**Planning Department
Transportation Development Services**

April 29, 2014

**Re: Diamond Mesa Phase 3, Bldgs 40-46, 85, and 88; 2300 Diamond Mesa Tr.
Submittal for Certificate of Occupancy – Transportation Development
Admin Amendment dated 2-13-14 (N09-D012)
Certification dated 04-23-14**

SITE DEVELOPMENT PLAN FOR BUILDING PERMIT DIAMOND MESA

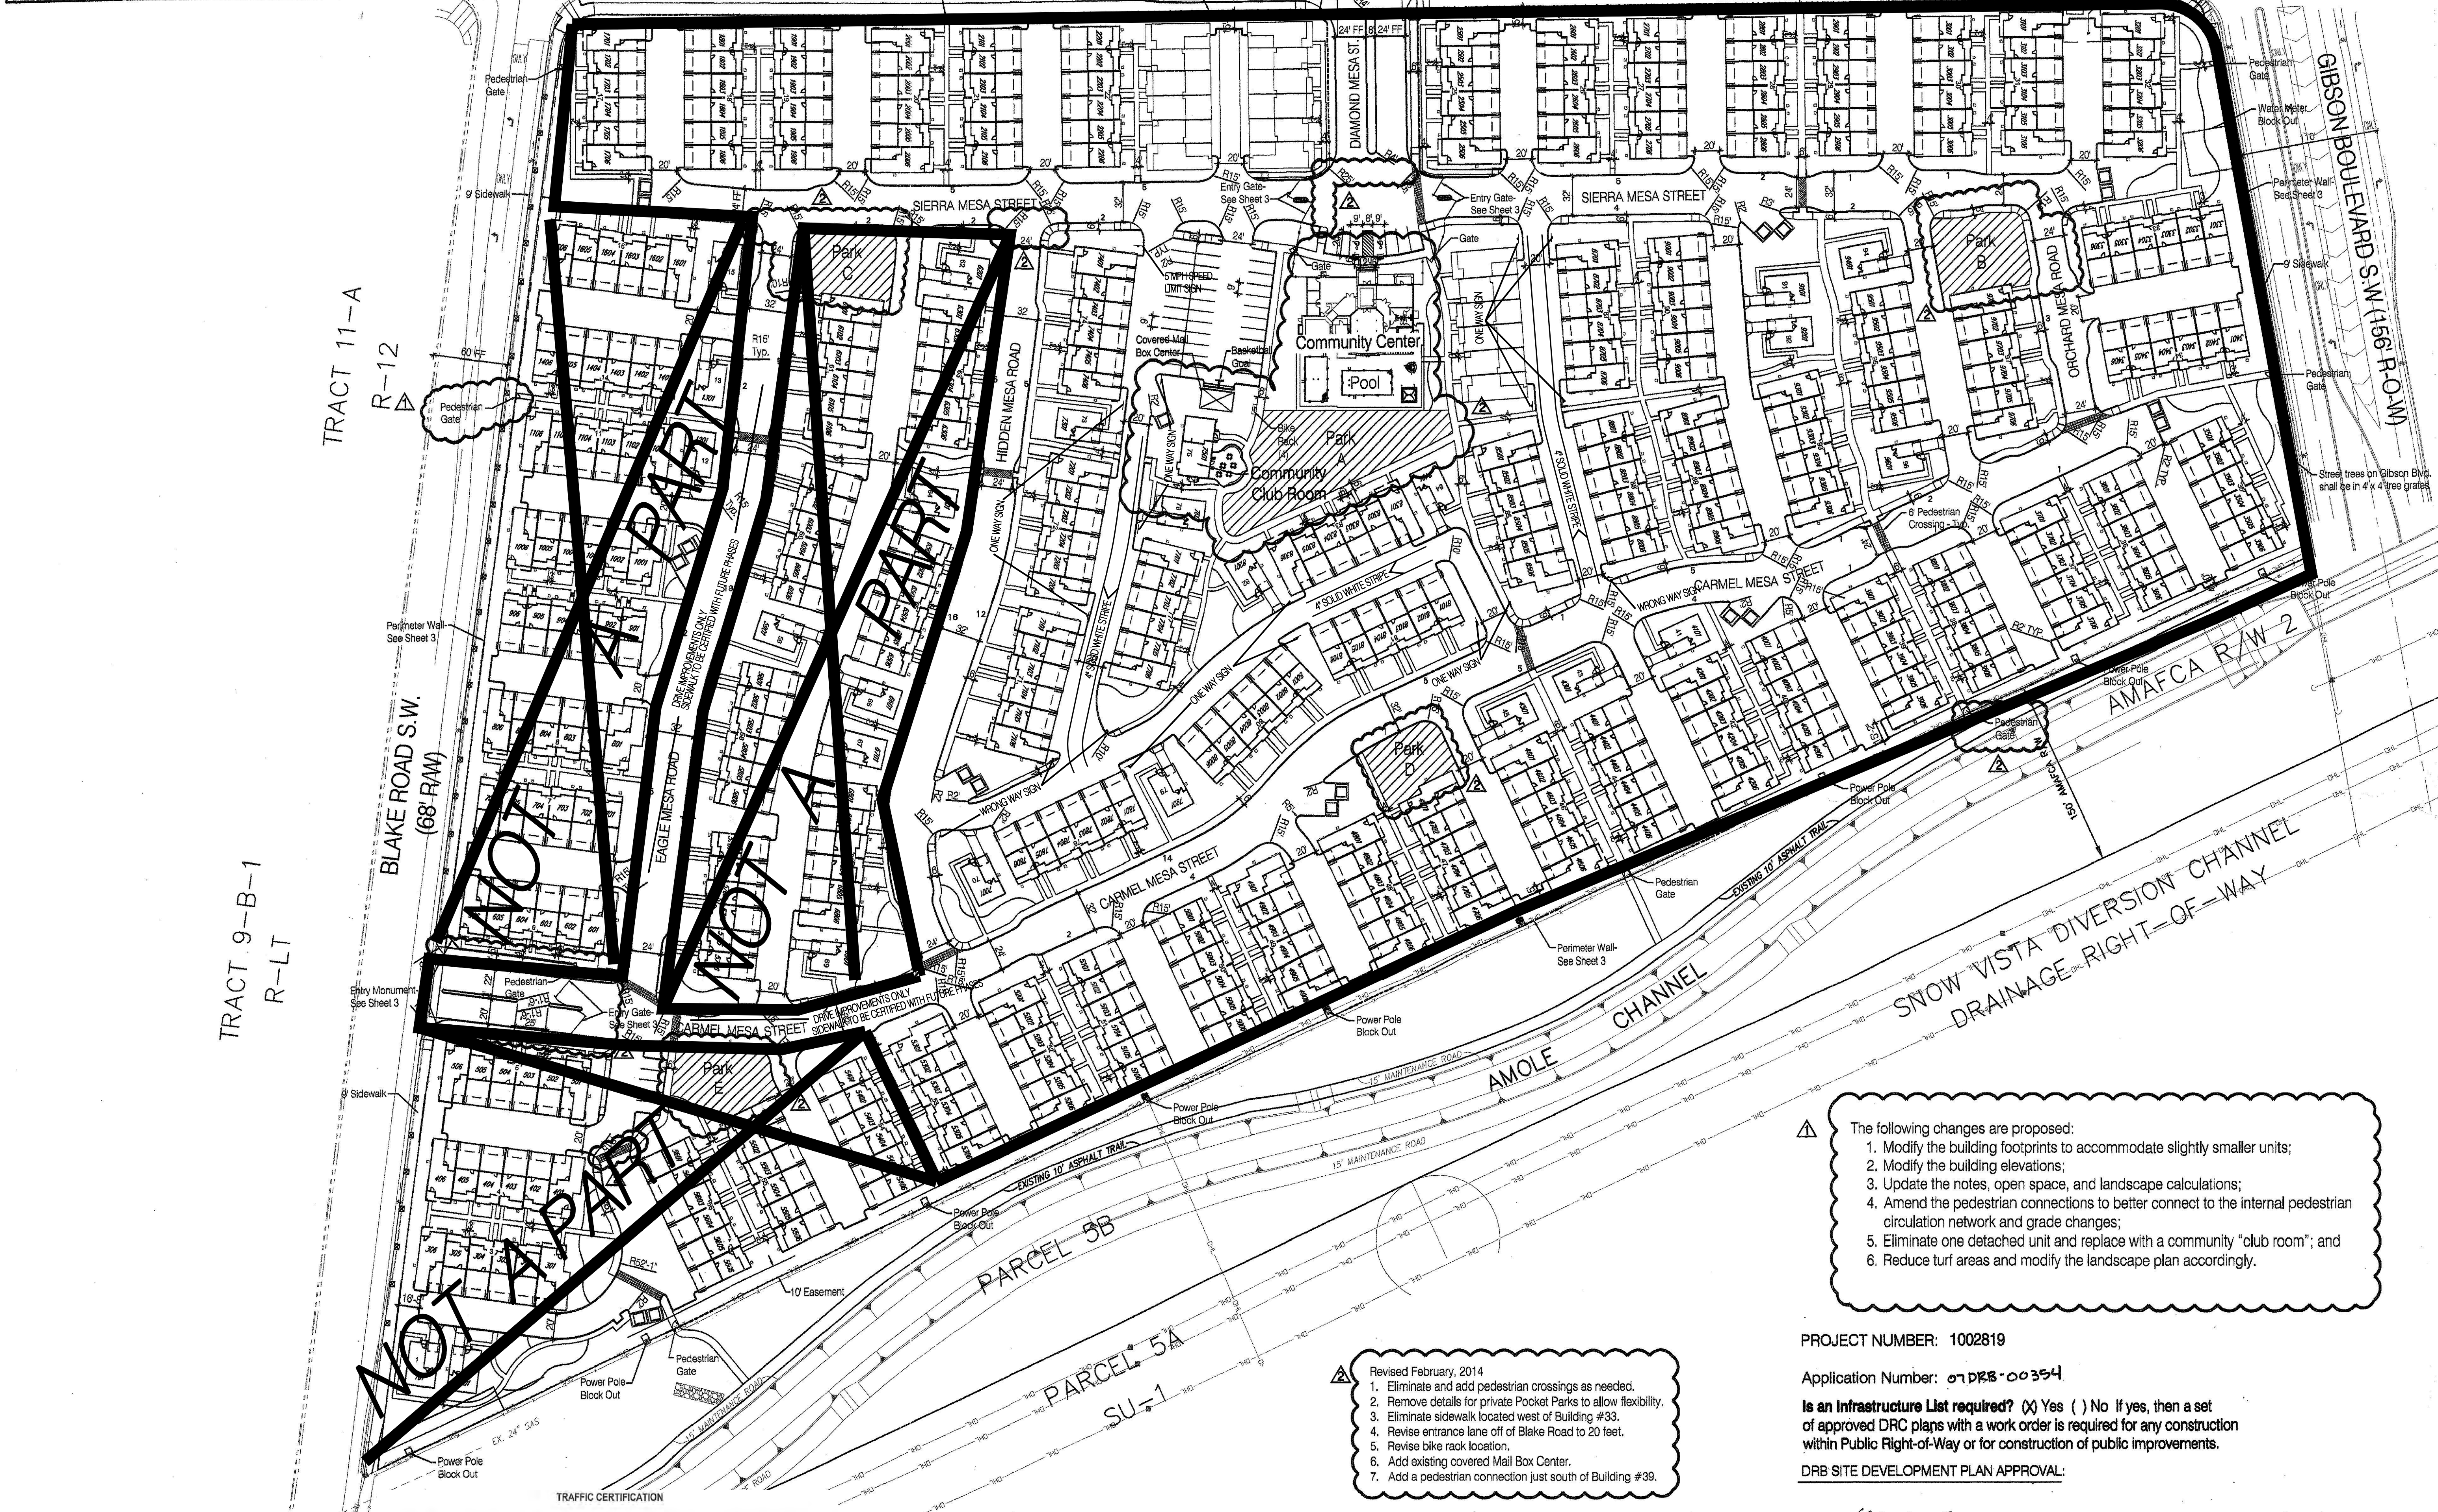
- Due to drop offs at the driveways, please sign and stripe the road between buildings 85 and 88 from Sierra Mesa to Carmel Mesa as a one way.
